**Town of Addison
Engineering Review
Conditional Civil Approval**

STORM DRAINAGE
PLAN SD-1

ADDISON GALAXY FBO
15601 ADDISON RD.
PREPARED FOR
BLACK FOREST VENTURE

SHEET NUMBER
C12.02

STORM DRAINAGE PLAN SD-1

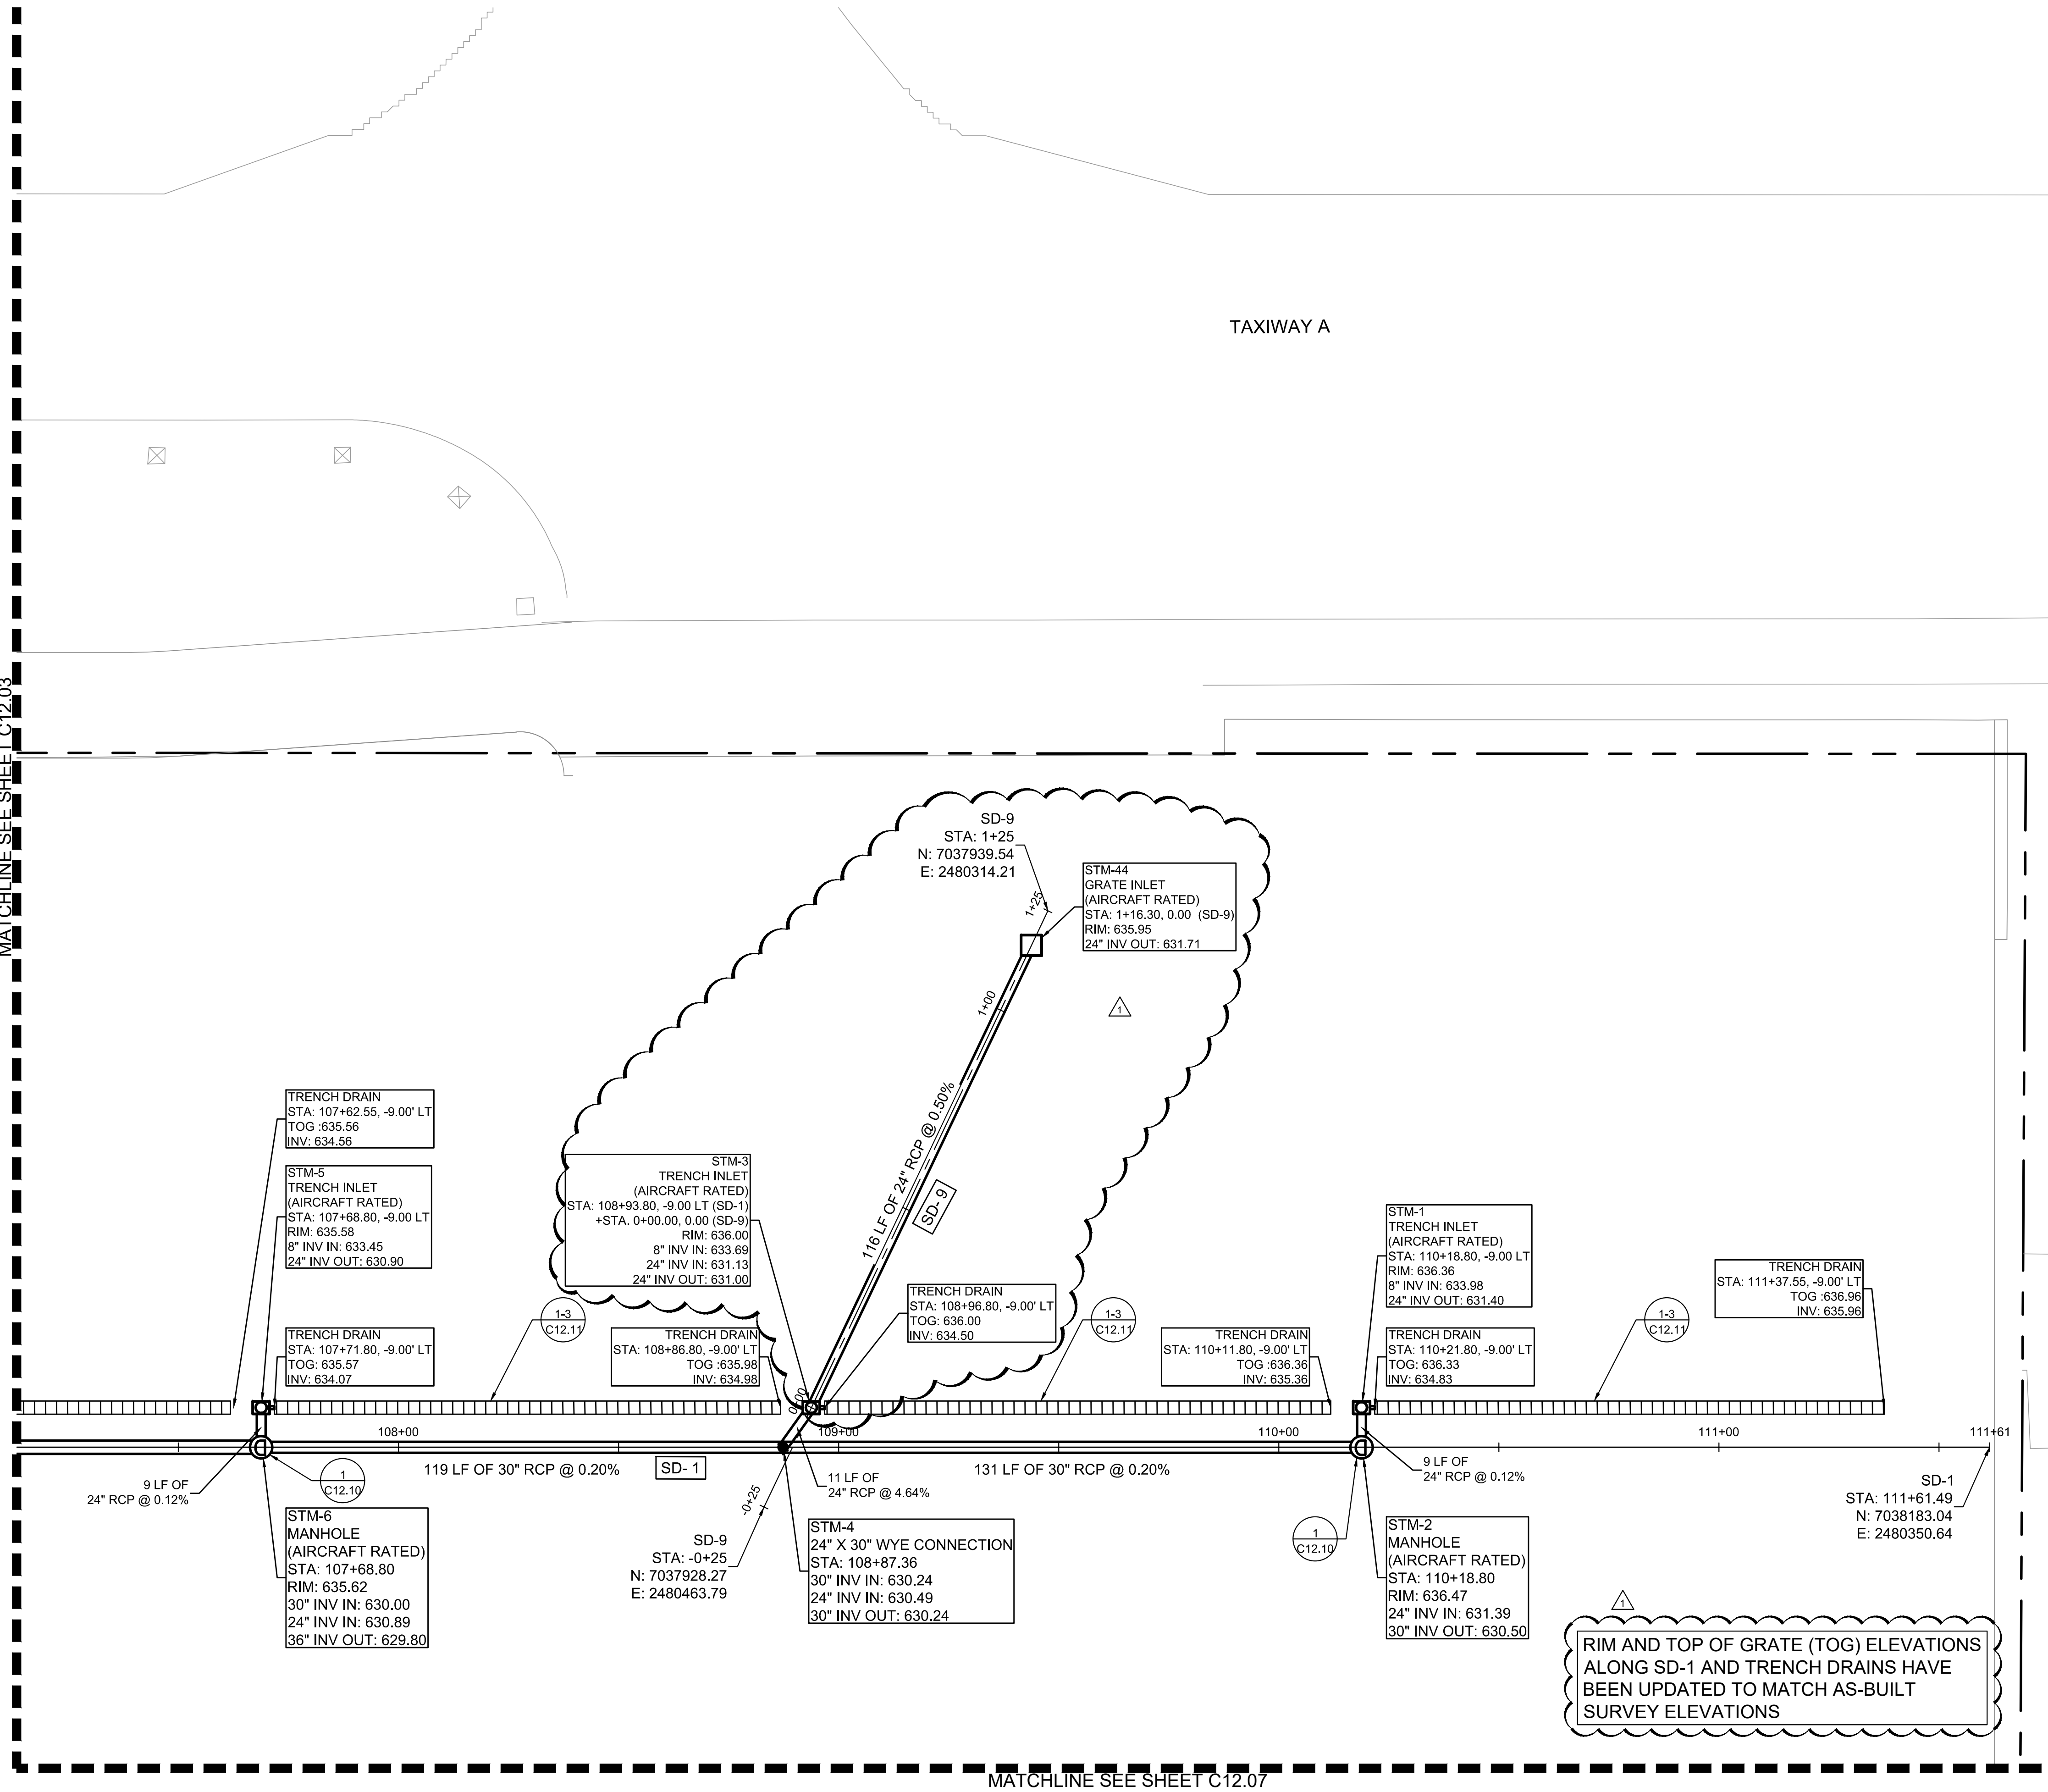
Lower a 10 LF section of the existing waterline (centered under the proposed 7' x 3' RCB) by a vertical distance of 6-inches so there is a minimum of 6-inches of clearance between the bottom of the RCB and the top of the lowered waterline section. Follow the Town of Addison standard "Water Main Lowering Detail" shown on this sheet to lower of the waterline with a pair of 45-degree vertical bends on each end of the 10 LF segment of the lowered waterline. Therefore, more than 10 LF of the existing waterline will need to be cut out and replaced so there will be a full 10 LF section of waterline pipe centered under the RCB that has 6-inches (minimum) of clearance from the bottom of the RCB.

Add note to lower XX LF per TOA SD
